Graham Evans
Senior Environmental Health Officer
Arun District Council

APPLICATION BE/1/13/

Site Address: Land adjacent to The Rising Sun 351 Chichester Road Bognor
Regis PO21 5AN

Description of Works: Redevelopment of land at the former Rising Sun PH and the
construction of 7no. new dwellings with associated landscaping
and parking.

APPENDIX 5 – PROPOSED SITE LAYOUT

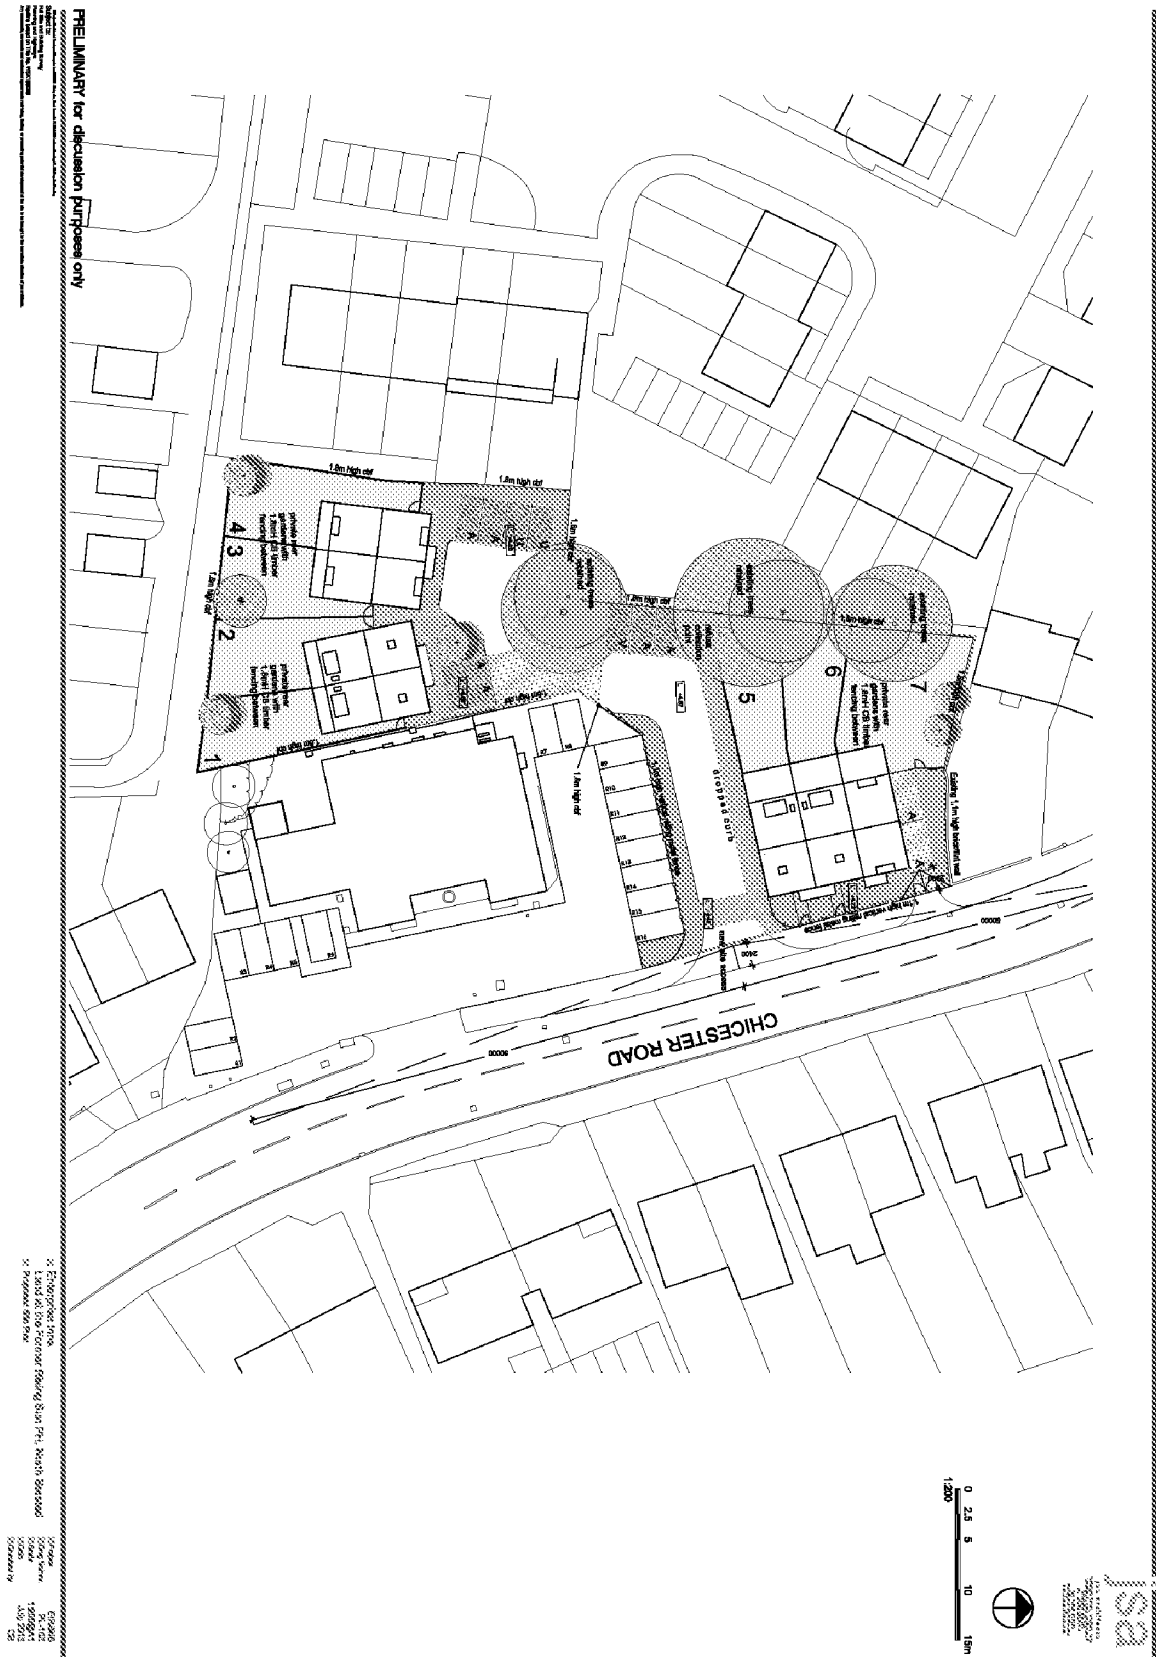
Nevertheless the proposal design indicates that gardens & amenity areas are screened from noise arising from the road. The orientation of the ground floor of plots 5, 6, & 7 places non-habitable rooms on the façade most exposed to noise from the A259. It is probable that an acoustic report would recommend double glazing and alternative means of ventilation to habitable rooms at first and second floor?

There is insufficient information to comment in respect of potential impact of plant and delivery noise from the adjacent convenience store upon the residential amenity of the proposed development, particularly in respect of plot 1 (the plan suggests plant may be in very close proximity?).
